RE YOUR REF: AB/39/19/PL
SIAN EGGINGTON
[REDACTED]

Development Application for Change of Use from Financial and Professional Services (class A2) to mixed use: Retail (Class A1) and staff offices.

Location 55-57 High Street Arundel

SURVEY - GROUND FLOOR PLAN

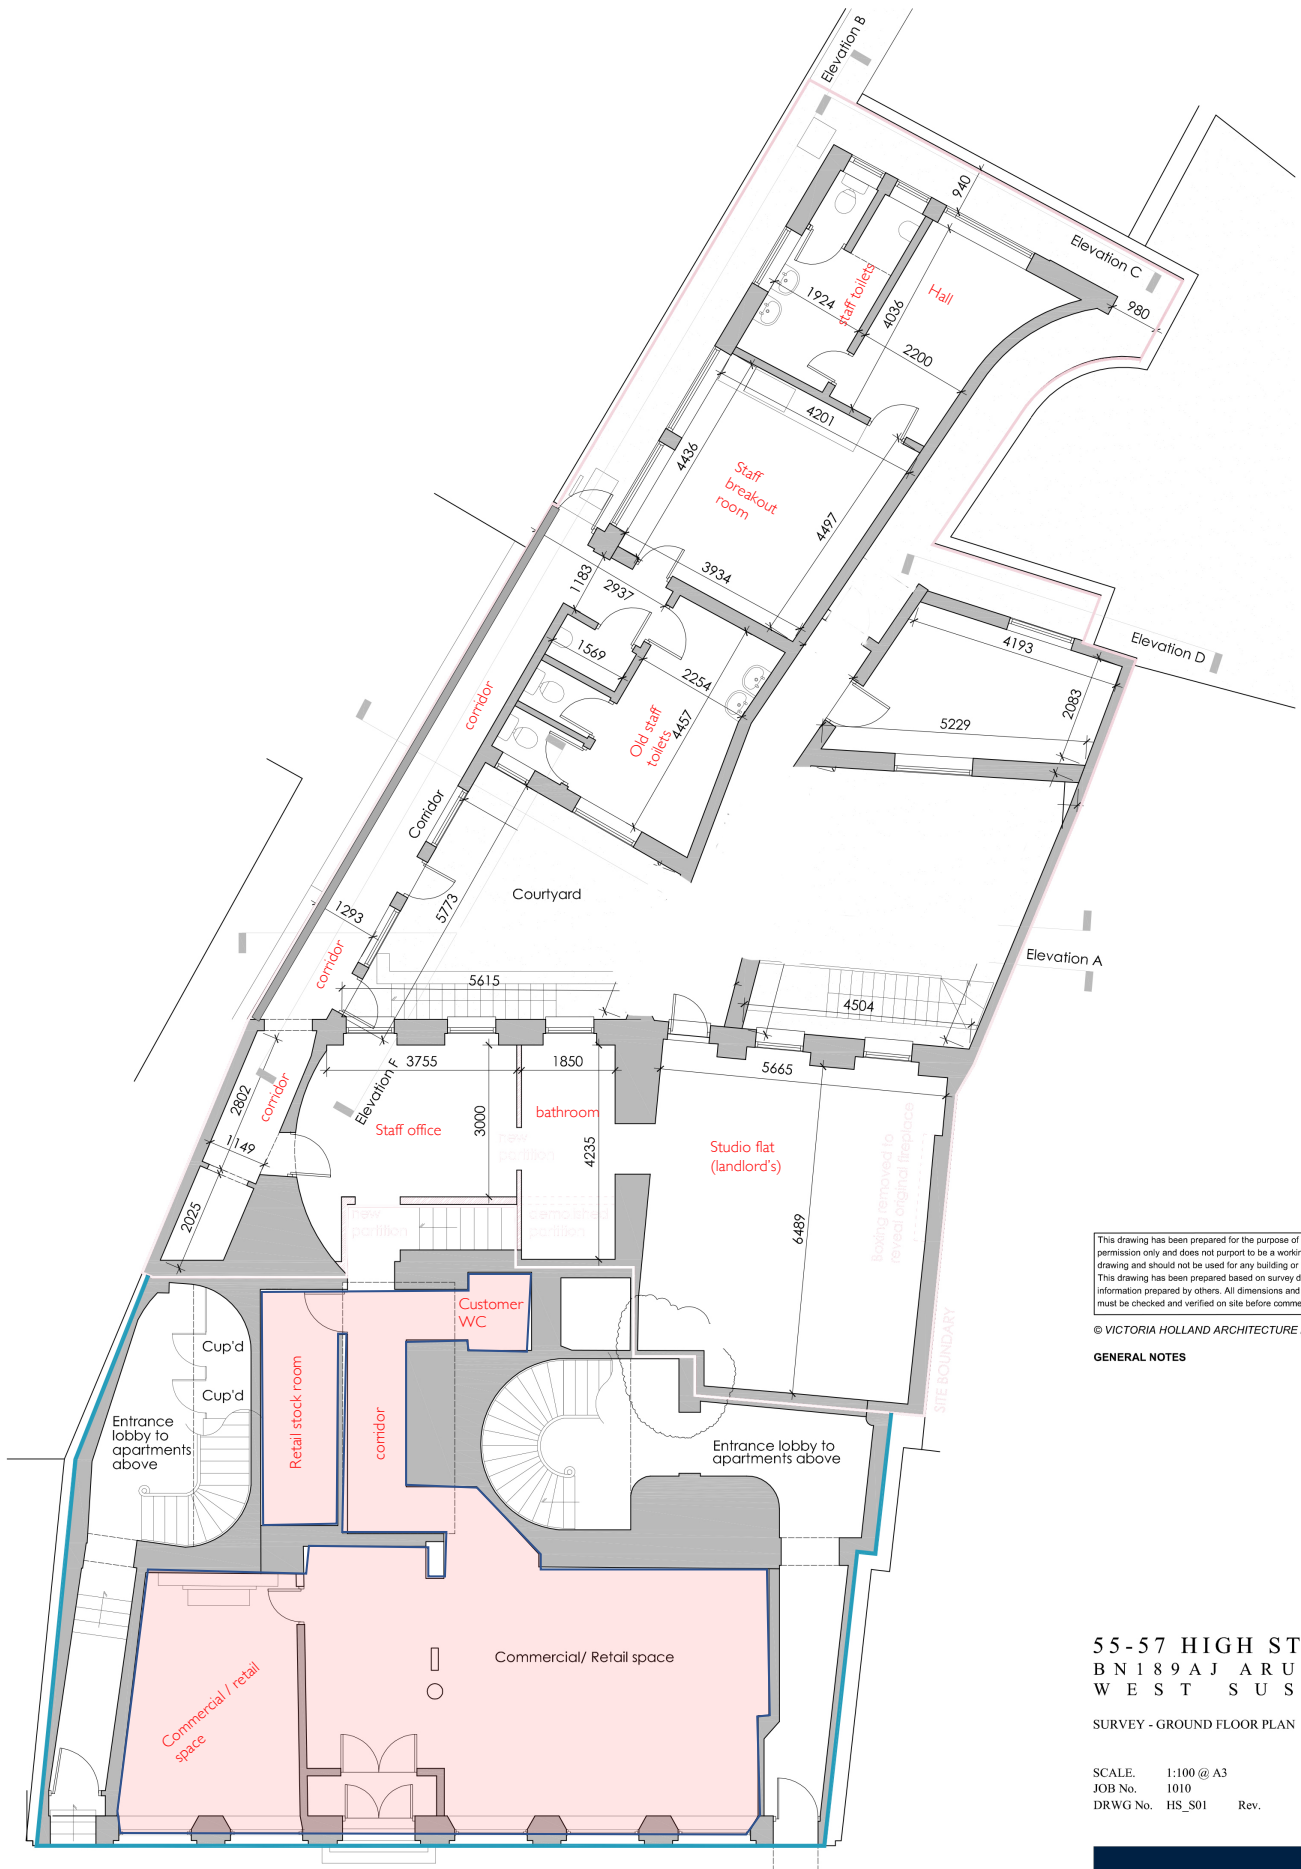
Existing Floor Plan: Please provide the existing floor plan with room labels to clearly illustrate the change of use.

- Demolition: yes, please go ahead and remove this section from the form as we are not touching the layout in anyway – thank you.
- Existing Floor Plan:
 - You had requested that we label the use of each room. I have done so in the attached floor plan, with all additional information to you in red text. I have also put a pinkish bounding box around what in my mind is the 'retail space', ie the space into which the public enter to experience our retail offering, and thus excluding the supporting office and staff spaces. Is that helpful? Does that perhaps simplify our request? I appreciate that the planning history on this property on this building is a little complex and so appreciate your guidance.
